Reference No: **2024/NM/90797/E**

Site Address: 14, Shirley Mount, Gomersal, Cleckheaton, BD19 4NL

Description: Non material amendment to previous permission
2020/91183 for erection of two storey and single
storey rear extension and external alterations

DECISION – Non-Material Amendment Approved

Drawing Title
PROPOSED EXTN

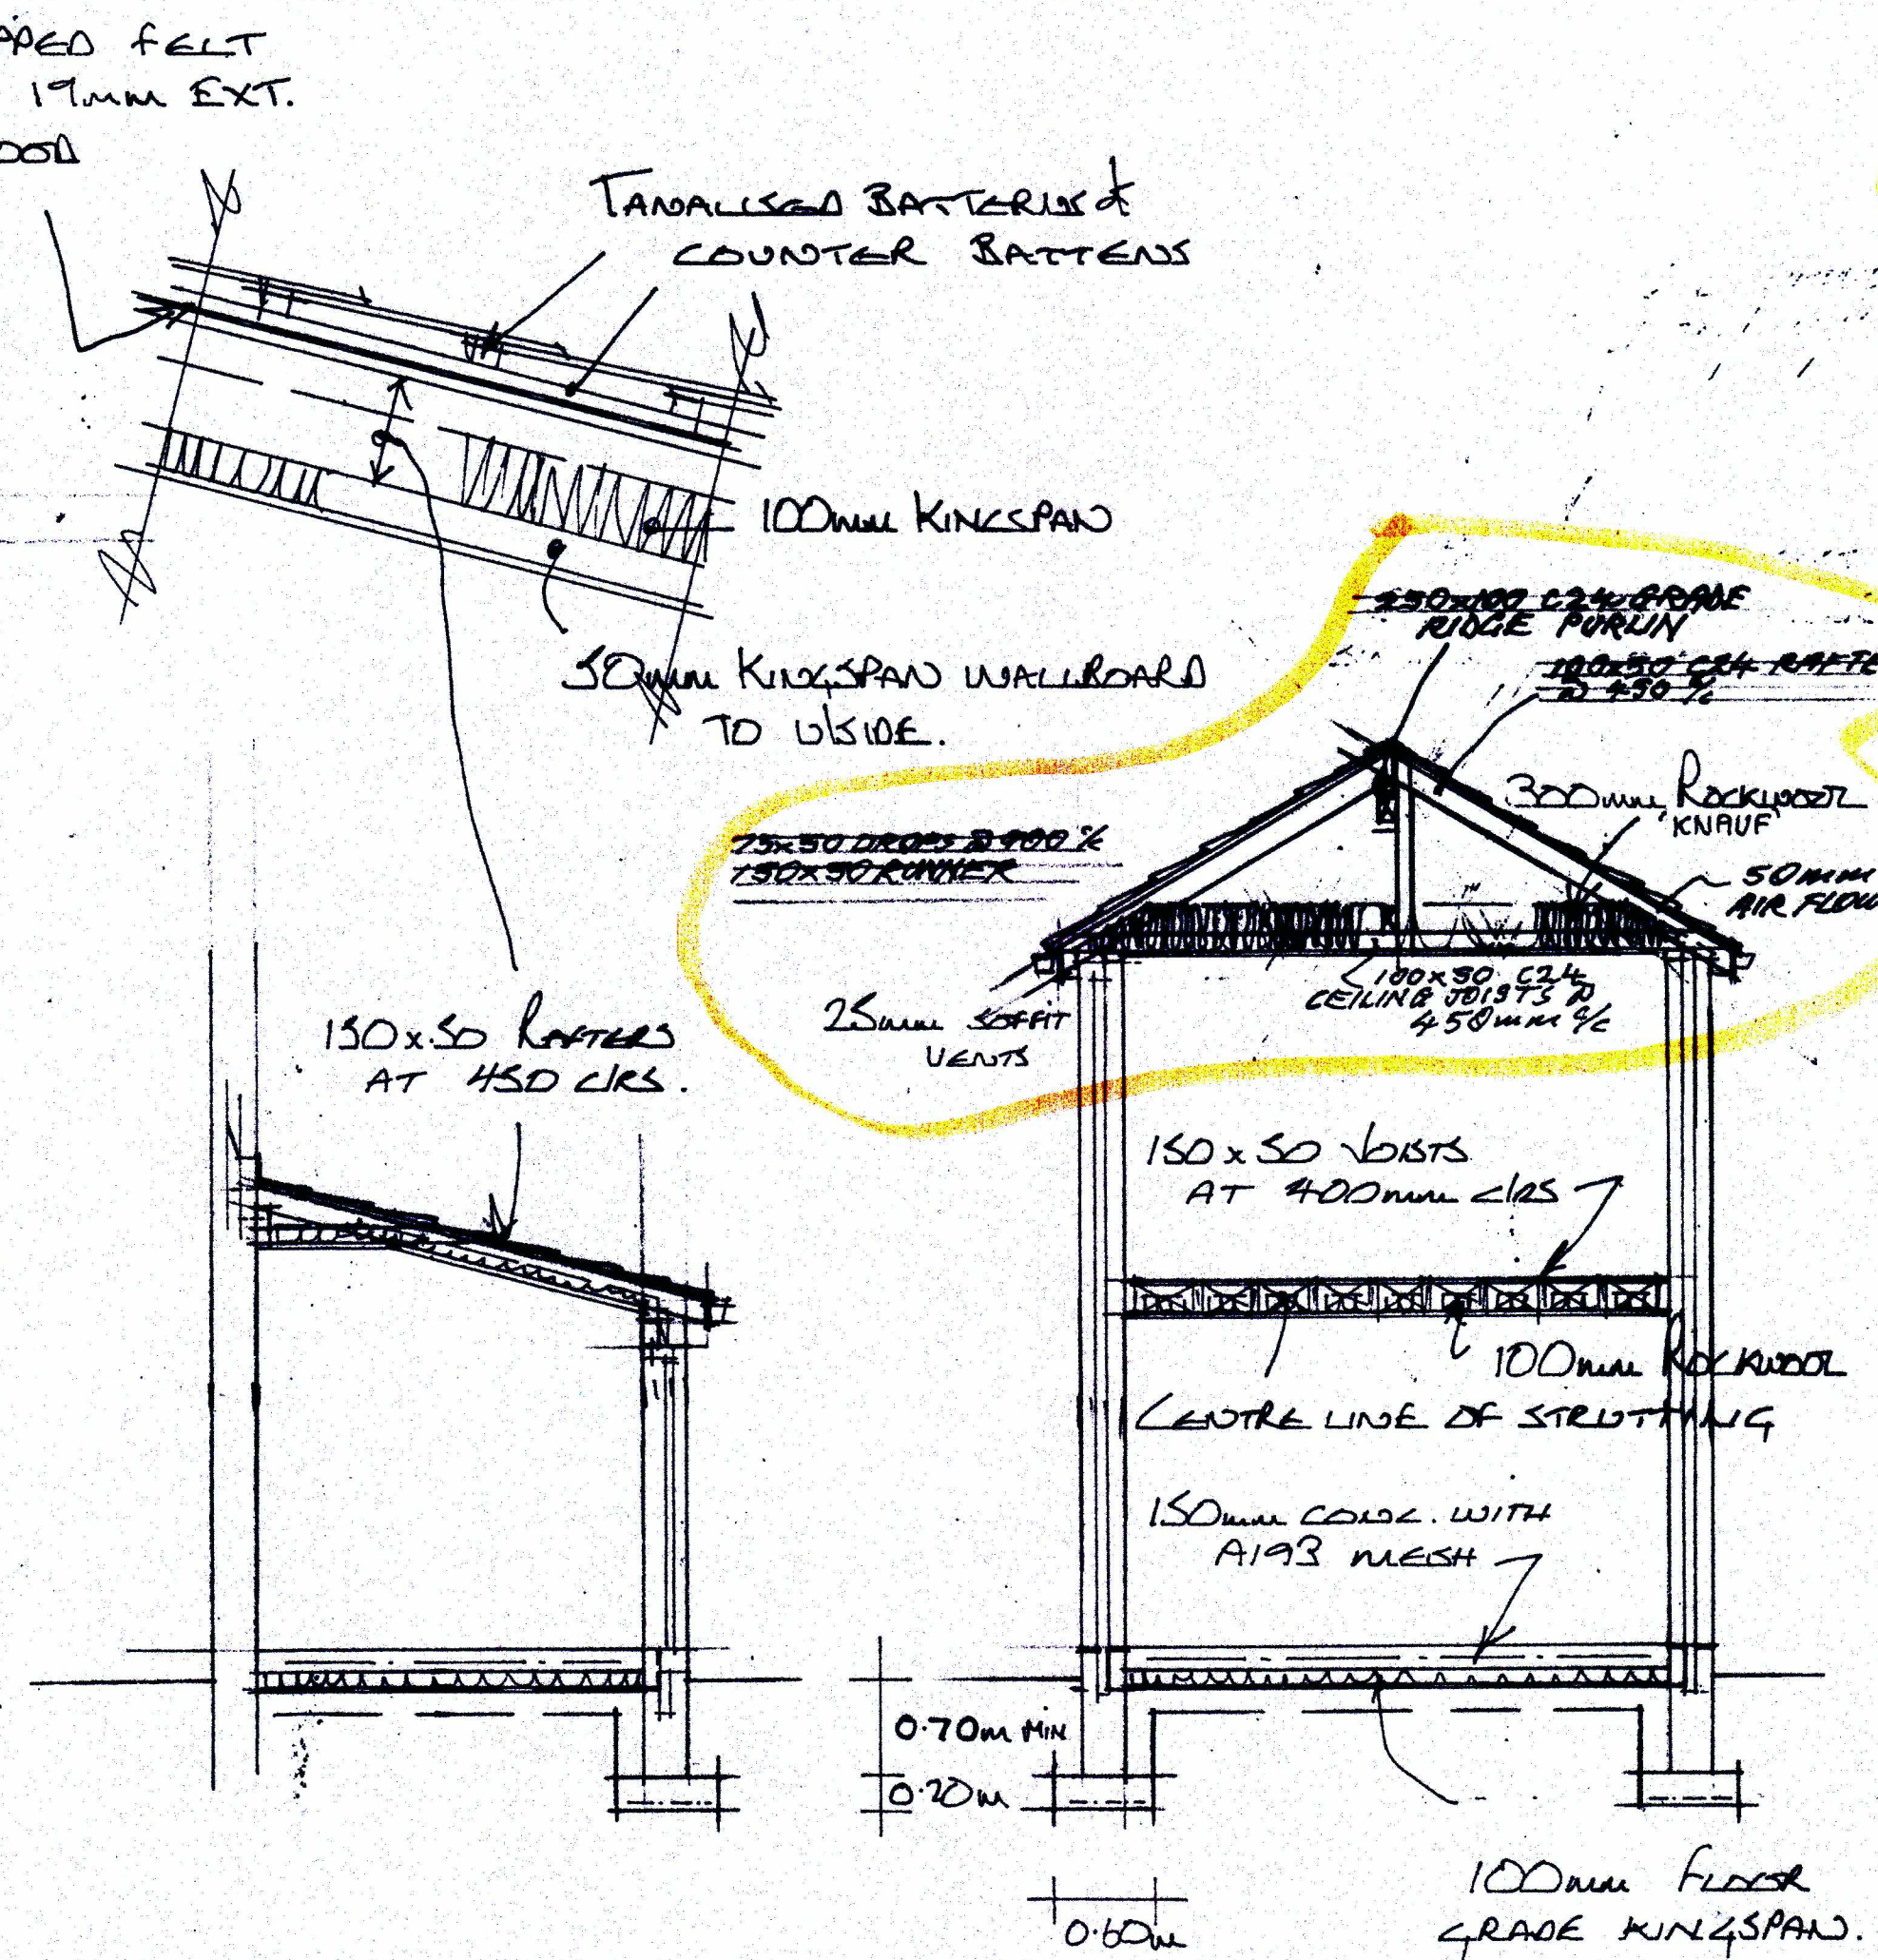
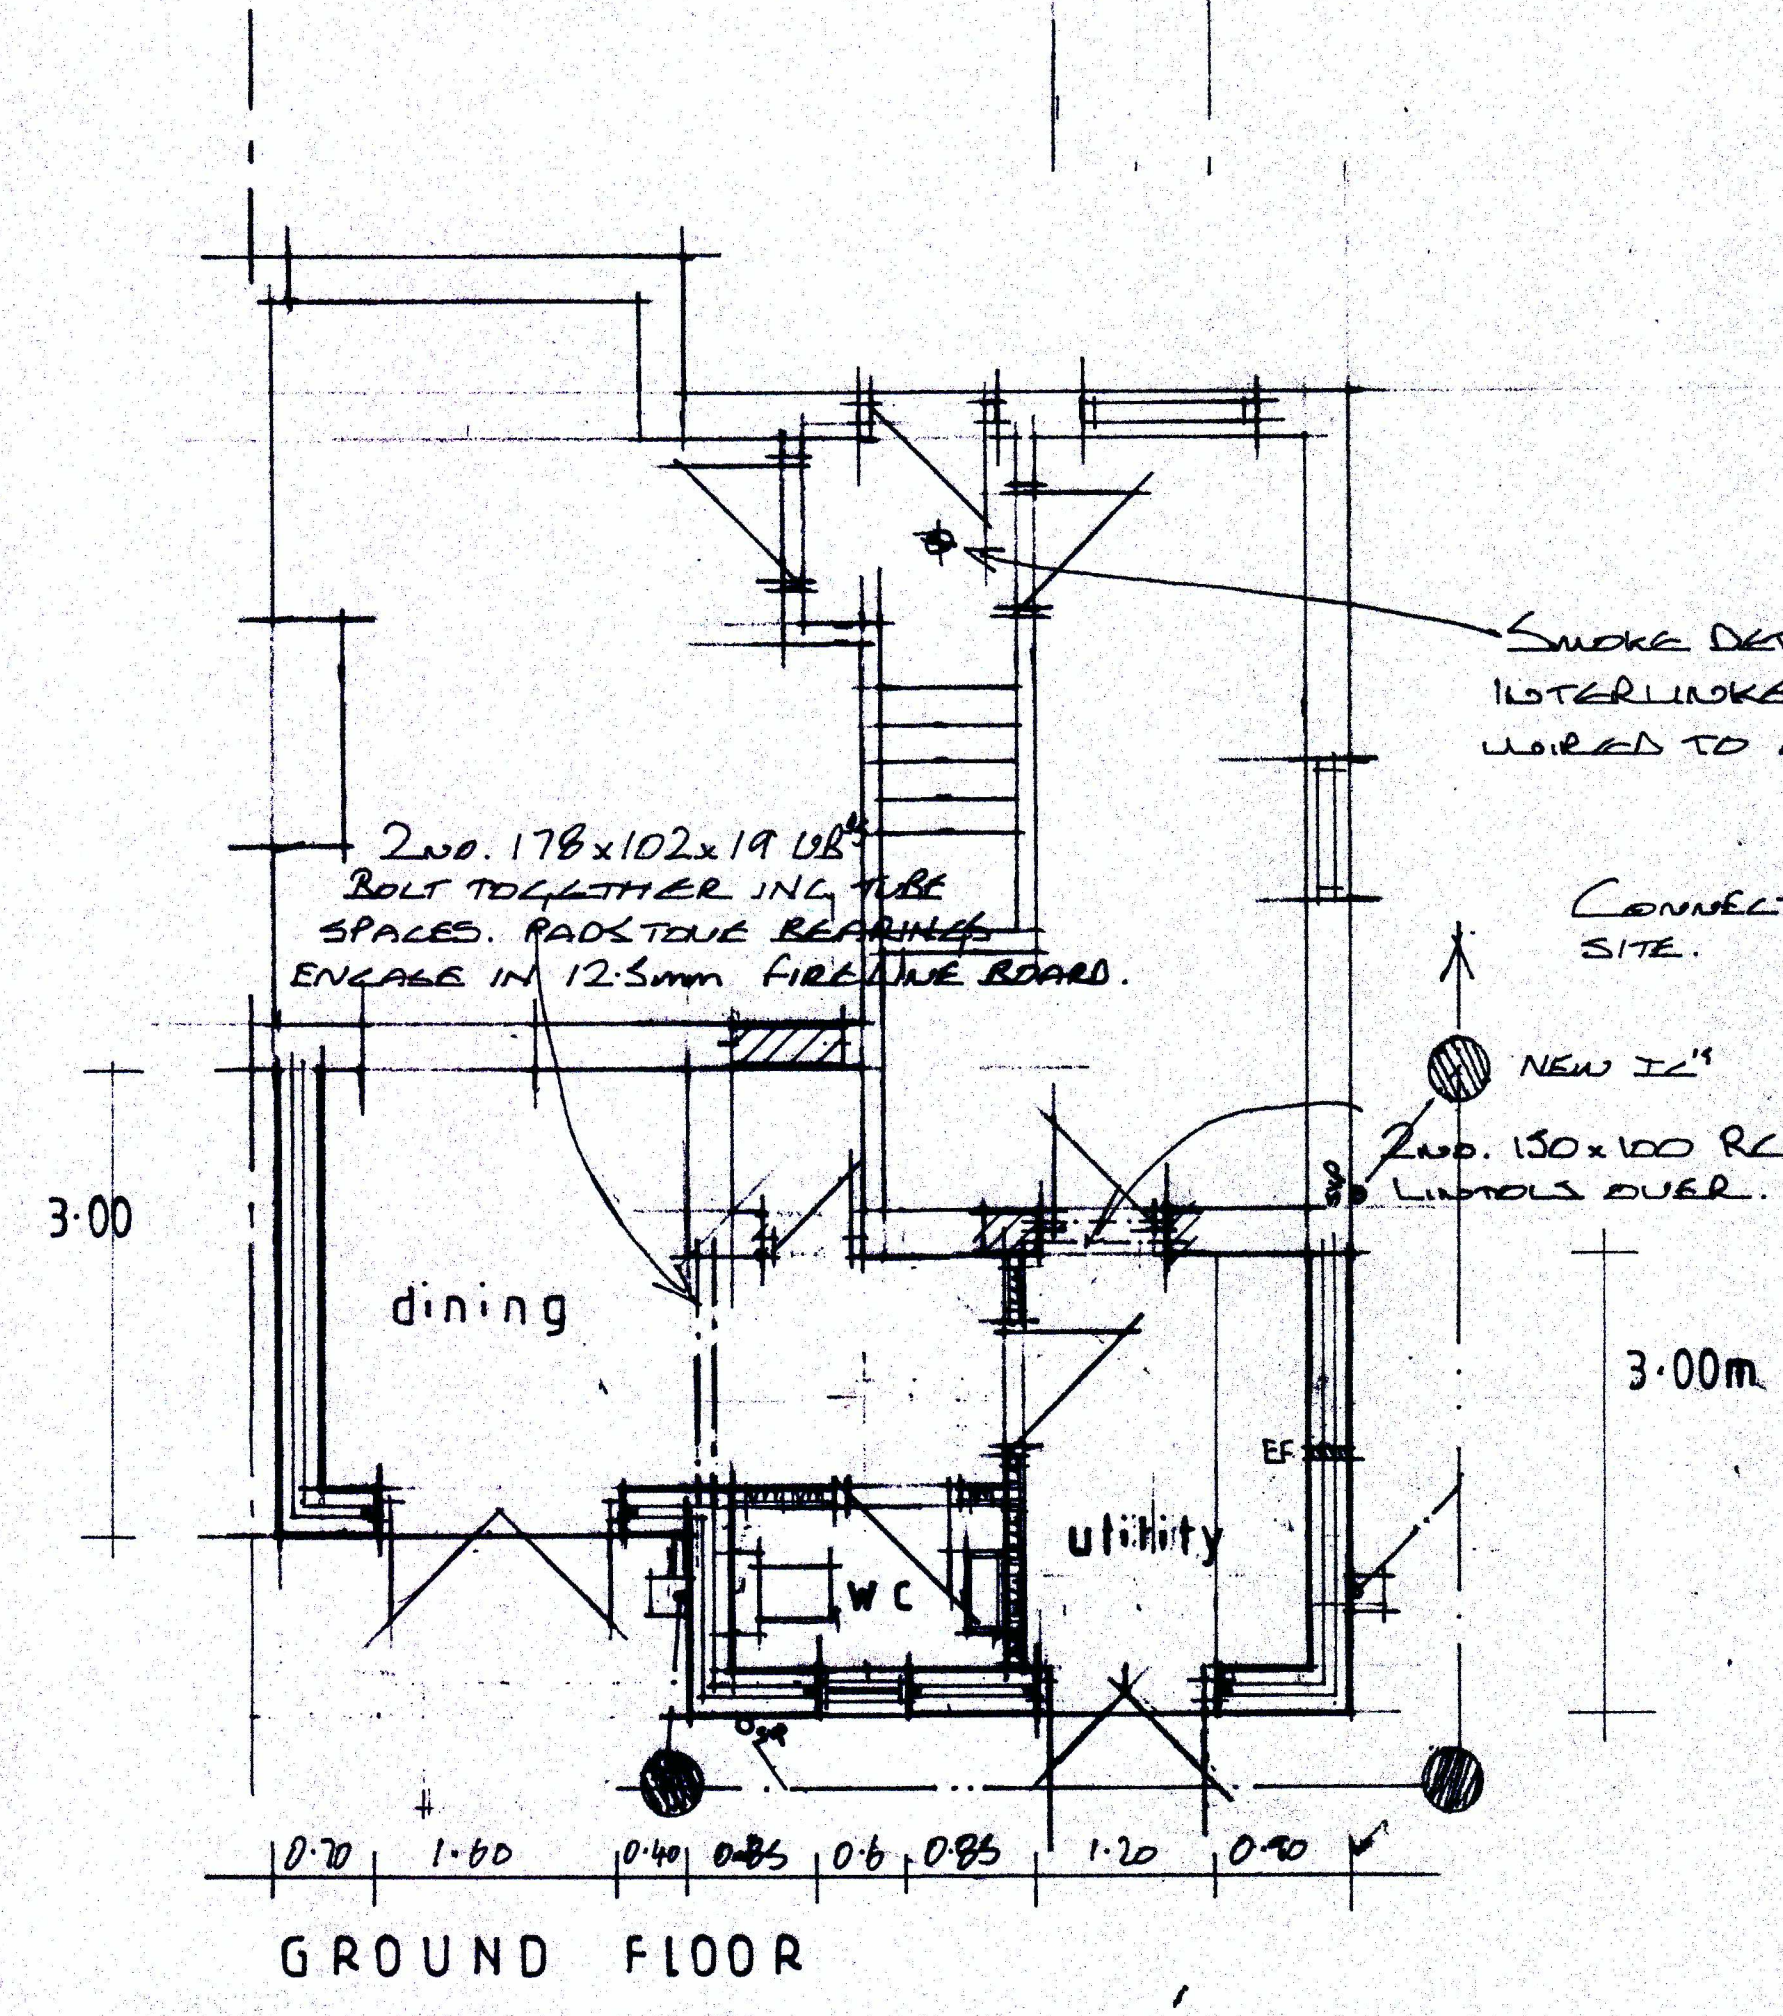
The amendment seeks to change the roof style on the two-storey section of the building from a hipped roof to a gable-end roof.

In terms of character, the development relates to a rear extension which is not visible from the public domain. Original roof types in the area are predominately hipped, including a rear extension of a nearby property. However, given the modest alteration, which is at the rear of the building, it would not be to the detriment of the character of the host dwelling or the character of the area.

In terms of impact to living conditions, the roof will be ~1.50m from the adjoining semi-detached building. Given the distance, there will not be a loss of outlook or a loss of light from the change to the roof shape. In terms of 13 Shirley Mount, there may be a minor reduction in sunlight observed in parts of the residential garden during the winter months when the sun is low, however the loss of sunlight is considered to be

minimal. Again, due to distance there will not be a loss of light in habitable rooms or outlook.

The alteration of a hipped roof to a gable-end roof would neither impact the character of the host dwelling or wider area, nor have an impact on the living conditions of neighbours.

On the basis of the above, the proposed change would be acceptable under the non-material amendment procedure and as such is recommended for approval.
